# Office of Environment & Heritage

DOC19/57130  
SSD 8859

## **Exhibition of Elizabeth Drive Subdivision located at 1111 - 1141 Elizabeth Drive, Cecil Park (SSD 8859)**

**Attachment 1 – Office of Environment and Heritage (OEH) comments - Exhibition of 1111-1141  
Elizabeth Drive, (Corner Cecil Road), Cecil Park SSD 8859**

Figure B-1

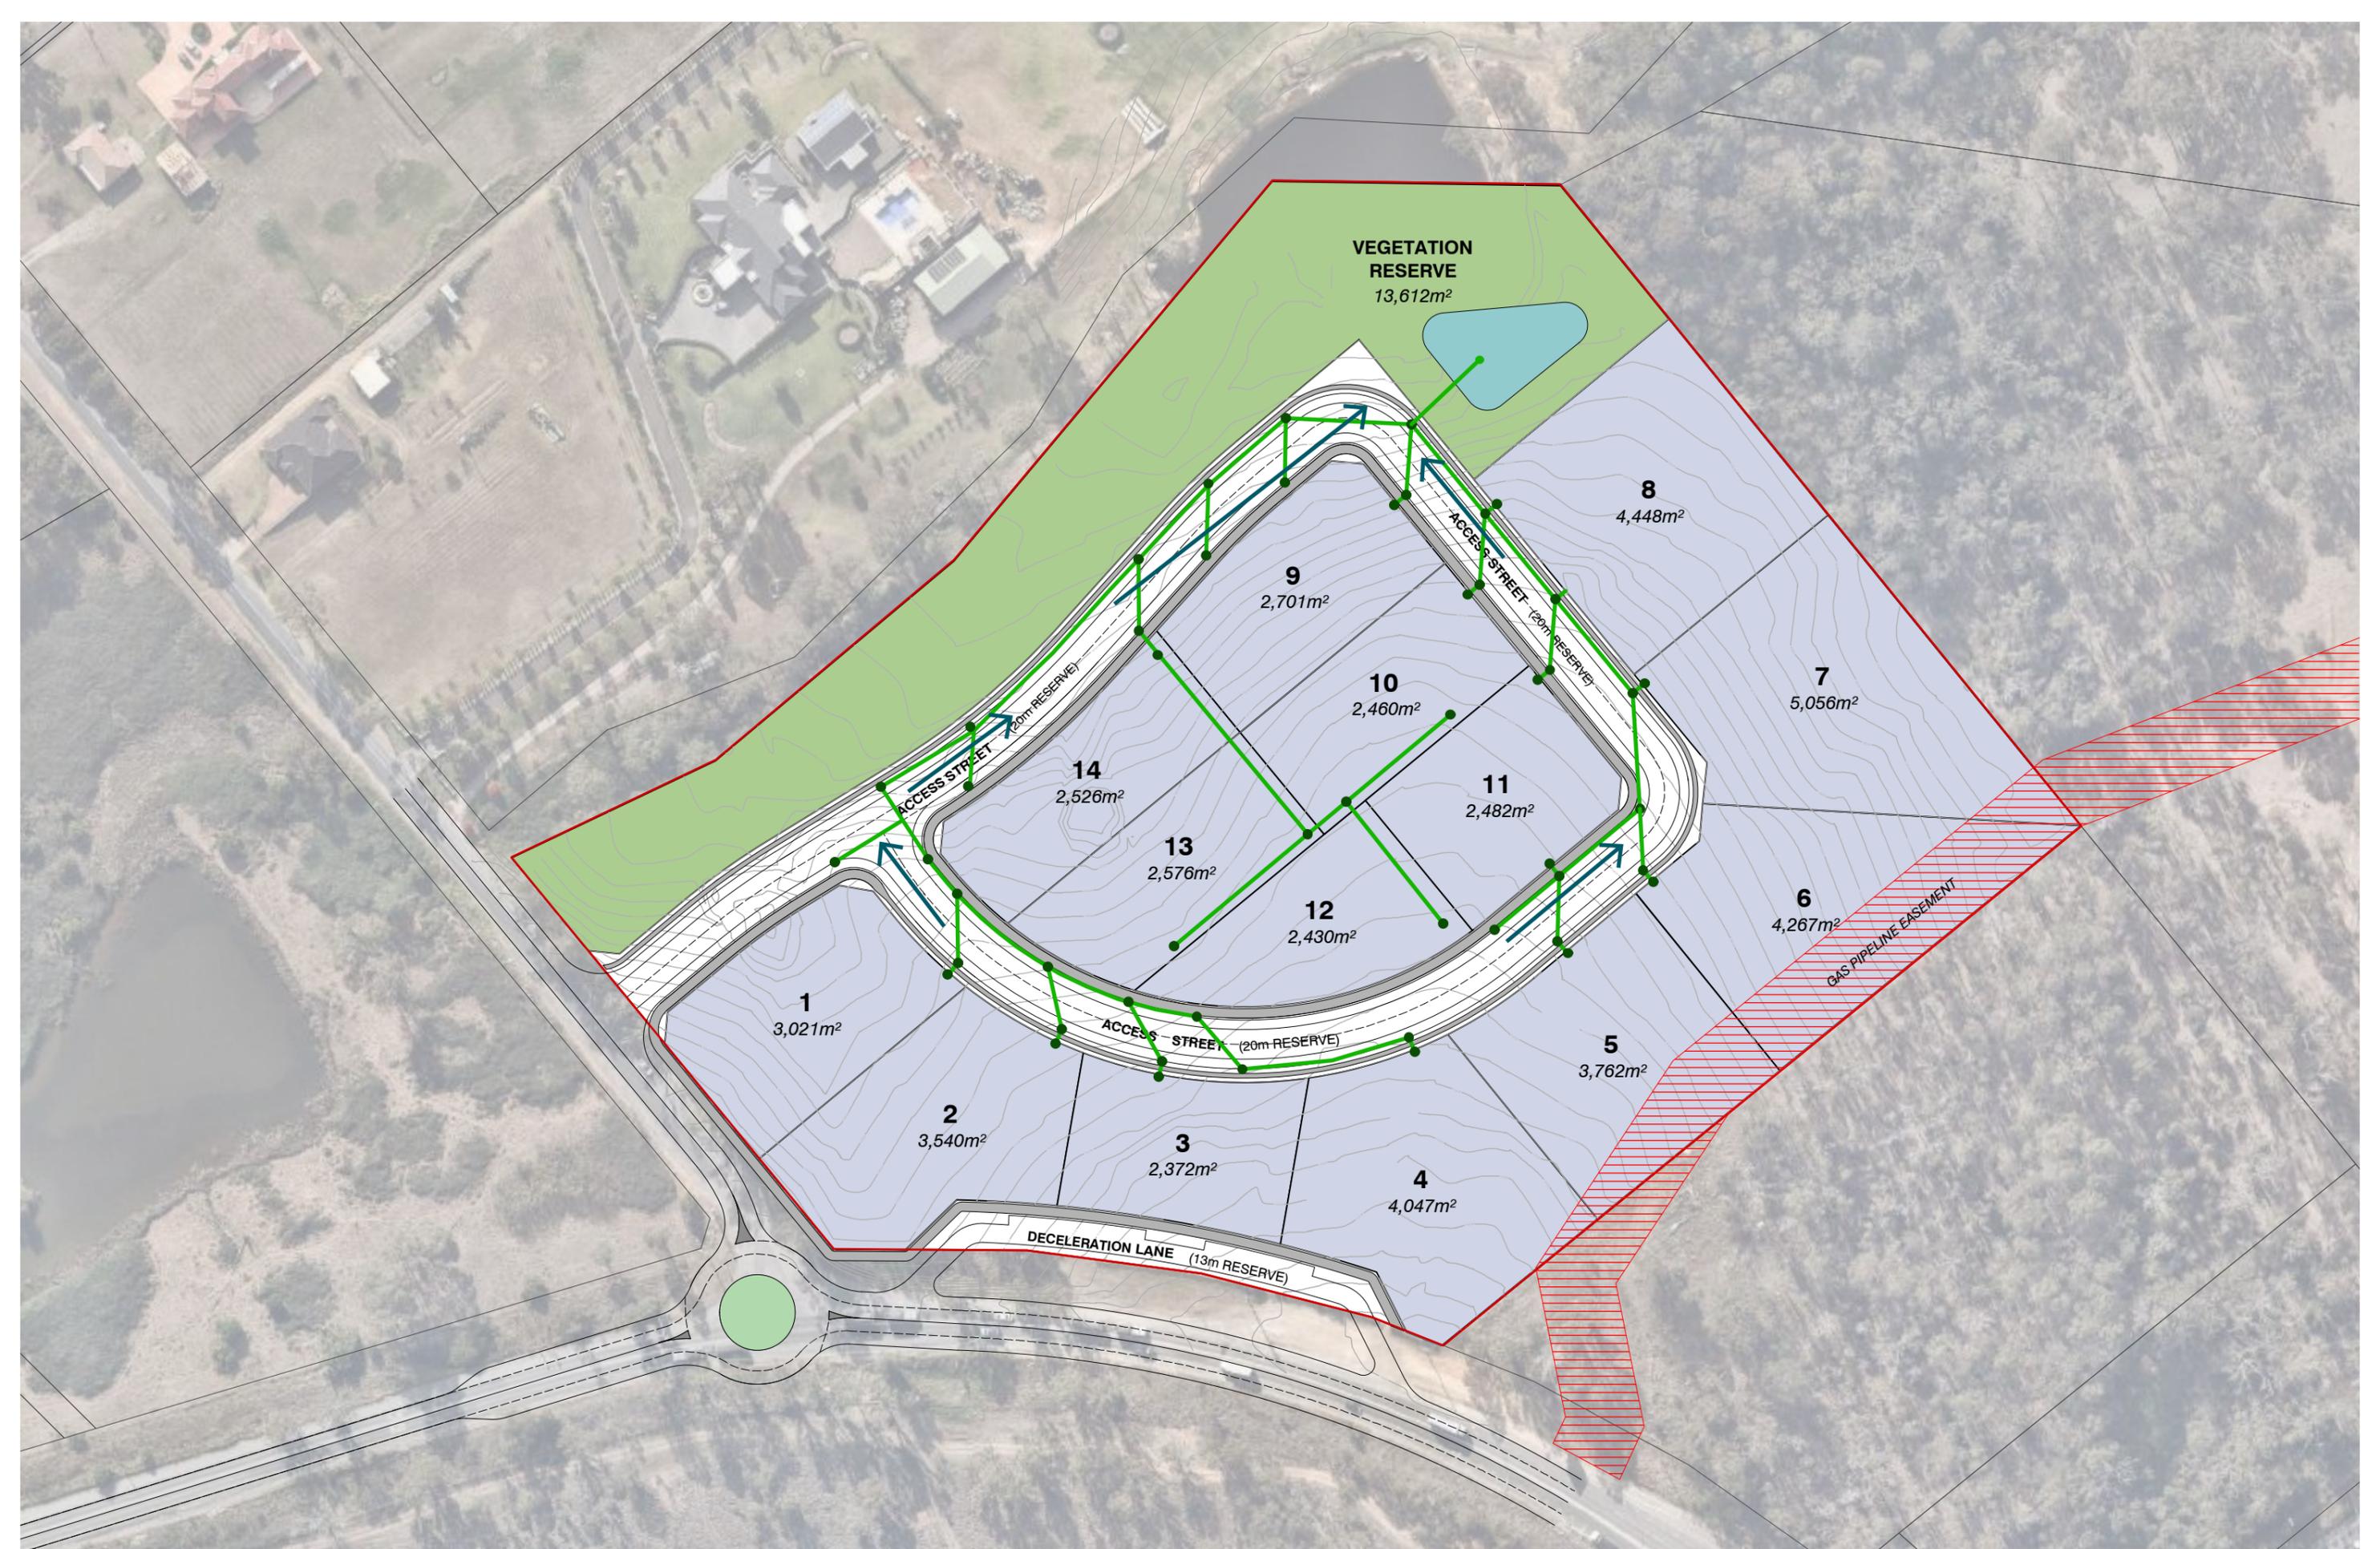
- a co-located flood detention basin and bioretention area, and their associated spillway (see Appendix B Stormwater Management Plan in *aeDesign Partnership Pty Ltd 2126819-REP-1111-1141 Elizabeth Drive DA Stage Stormwater, Flooding and Dams* (GHD October 2018)) and

Importantly, the report states in its assessment of serious and irreversible impacts (SAIIs) (see page 54), that the proposed vegetation reserve will not be impacted by the proposal. However, this area will be directly and indirectly impacted by the above-mentioned stormwater works.
